**REQUEST**

Current Zoning: R-3 AIR LLWPA (single family residential, airport noise overlay, Lower Lake Wylie Protected Area) and B-2 AIR LLWPA (general business, airport noise overlay, Lower Lake Wylie Protected Area)  
Proposed Zoning: I-1(CD) AIR LLWPA (light industrial, airport overlay, Lower Lake Wylie Protected Area)

Approximately 13.22 acres located on the north side of Business Center Drive and Interstate 85 and west of Little Rock Road.

The petition proposes to rezone a vacant site to accommodate a maximum 175,000 square foot building that could be devoted to office, warehouse, distribution, outdoor storage, and other light industrial uses.

October 12, 2020

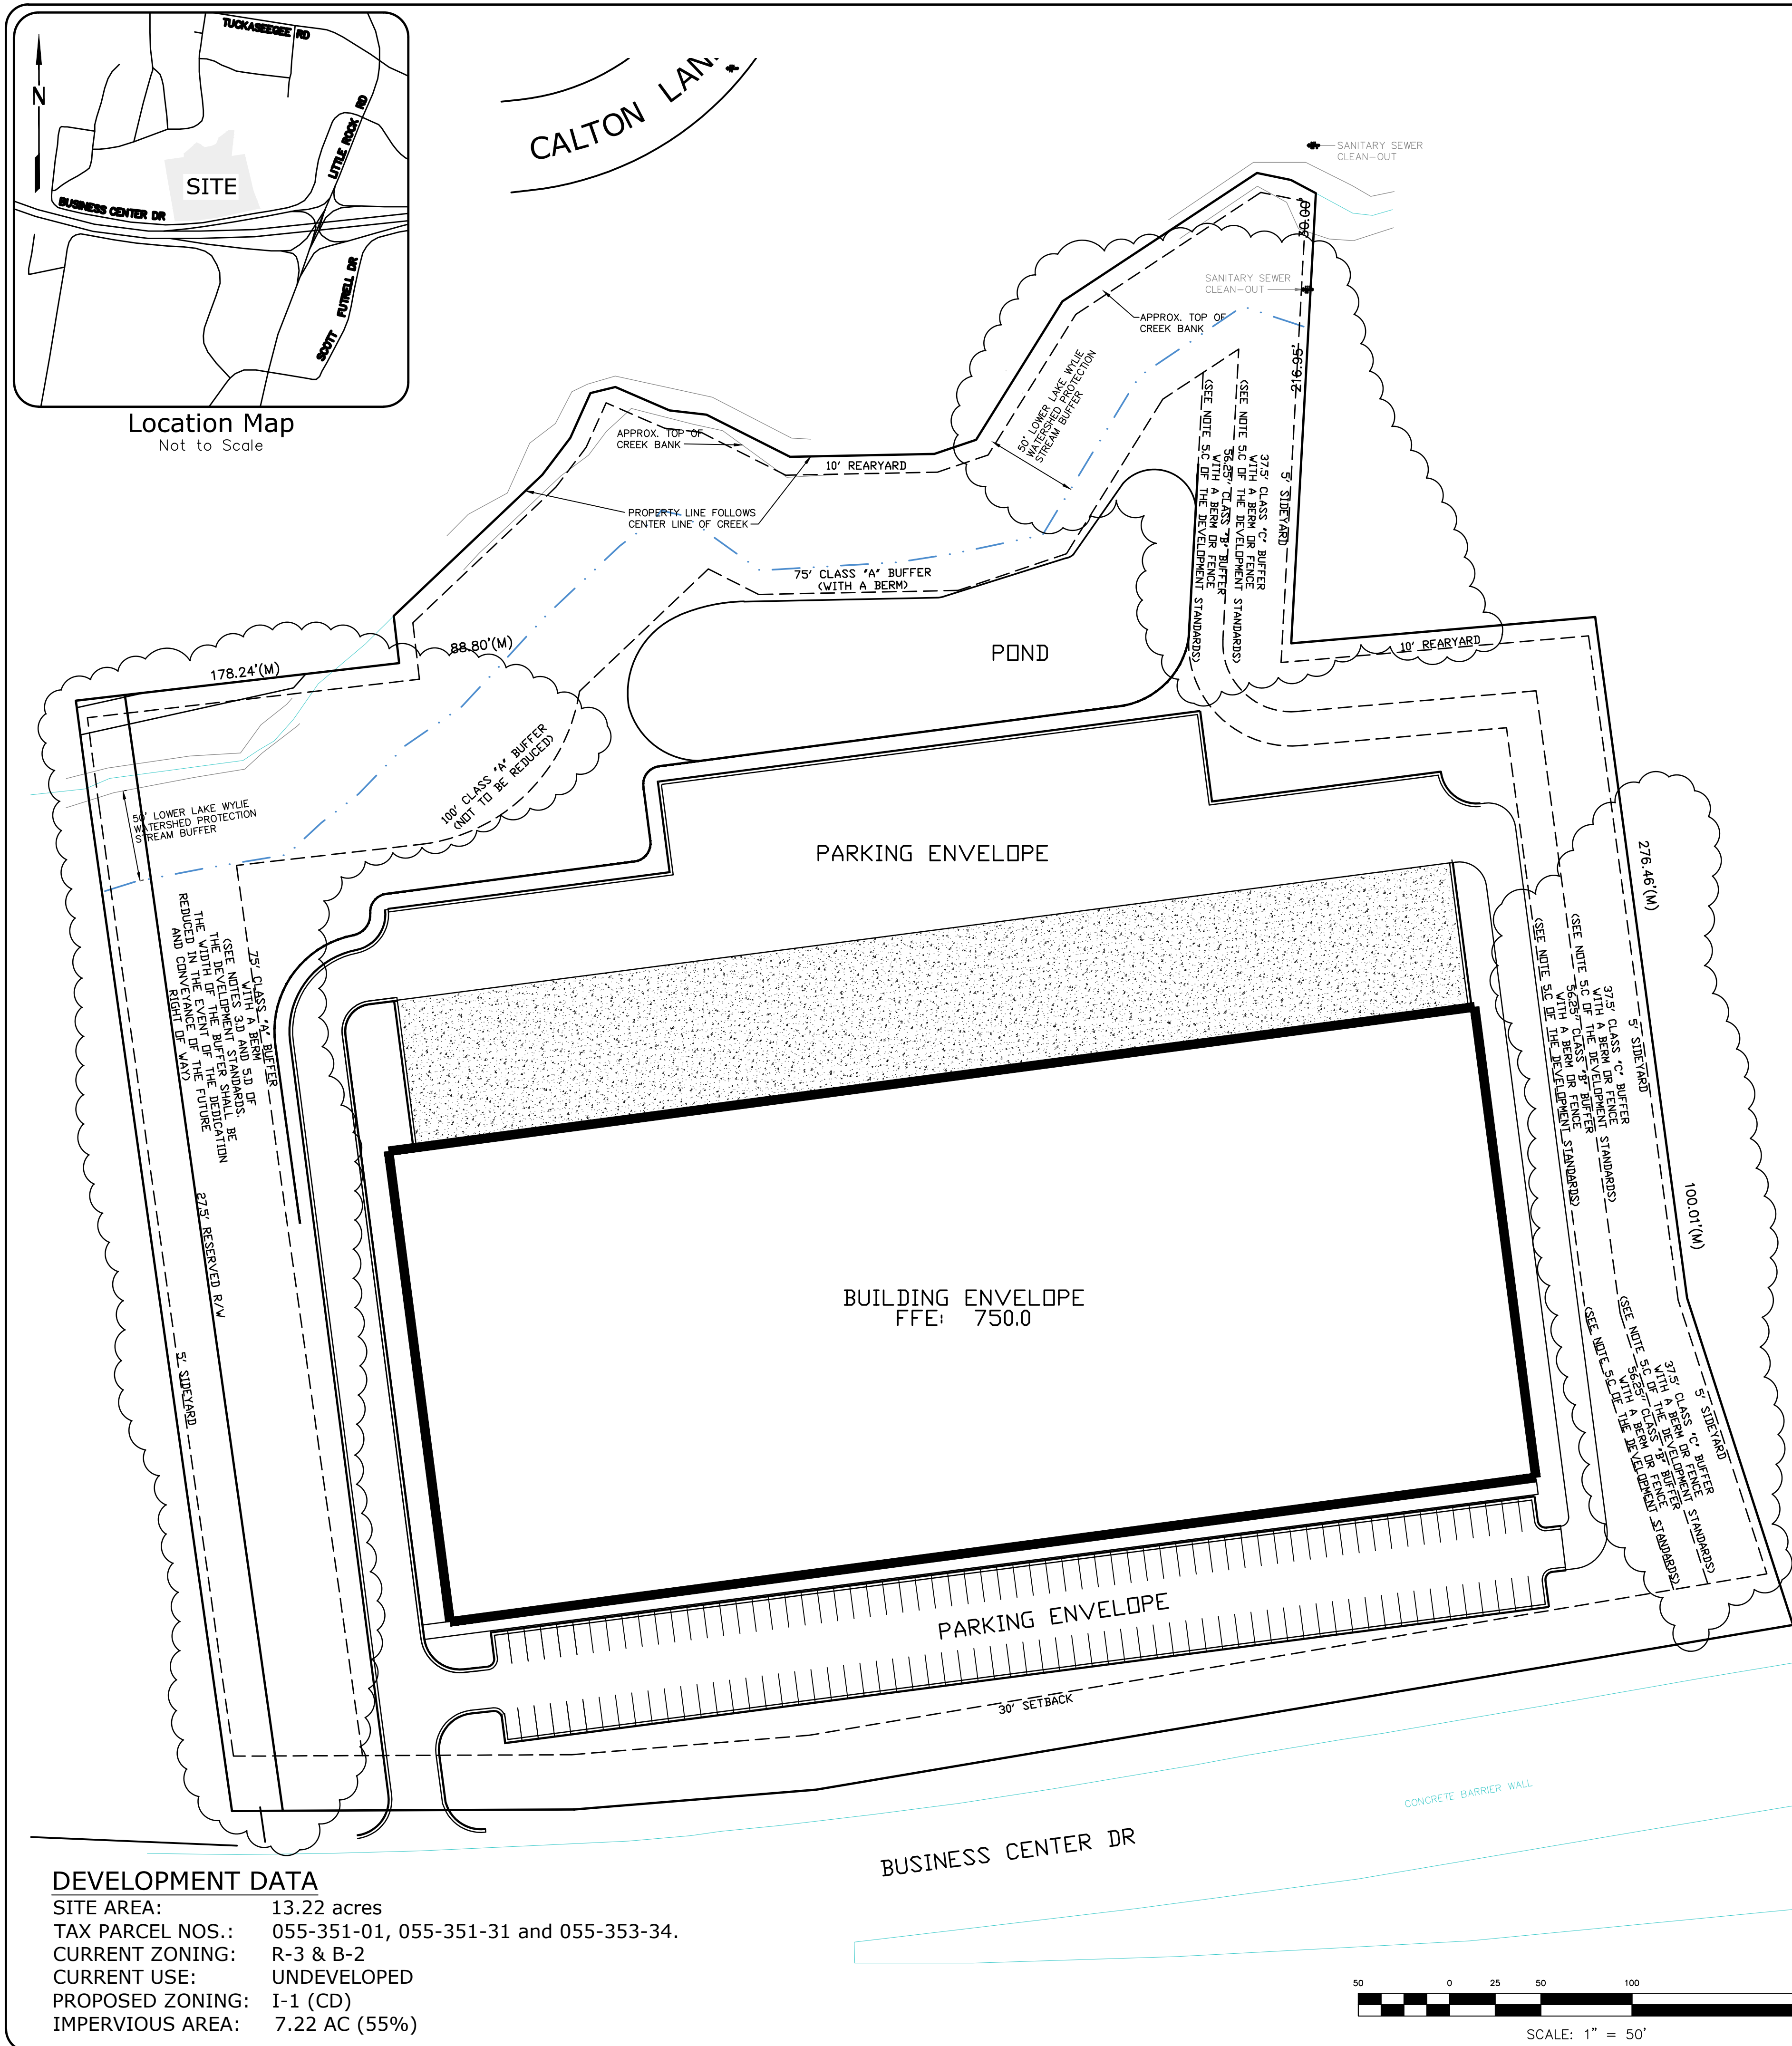
- ~~1. Revise the site plan and conditional note(s) to commit to dedicate right of way 2 ft back of sidewalk on Business Center Drive, labeled and dimensioned from the road centerline. ADDRESSED~~
- ~~2. Revise the site plan and conditional note(s) to commit to construct an 8-foot planting strip and a 6-foot sidewalk along the site's Business Center Drive frontage, per Charlotte WALKS, labeled and dimensioned from the road centerline. ADDRESSED~~

- ~~3. Stream buffers are incorrectly labeled. Applicability of stream buffer requirements will depend upon stream classification ("intermittent" stream will require 35' PCSO Buffer; "perennial" stream will require 100' watershed buffer). For purposes of advancing the rezoning process, show and label "Potential 35' PCSO Stream Buffer" and "Potential 100' Undisturbed Lower Lake Wylie Watershed Protection Stream Buffer" on the rezoning plan OR provide stream delineation report confirming no intermittent or perennial stream exists (report subject to review and approval by City). ADDRESSED~~

- ~~5. Label zoning of all adjacent parcels. ADDRESSED~~
- ~~6. Relocate the berm on the western property line to be outside of the reserved right of way. If future right of way is dedicated, a half buffer (50') is required and can be reduced 25% per ordinance with a berm. ADDRESSED~~
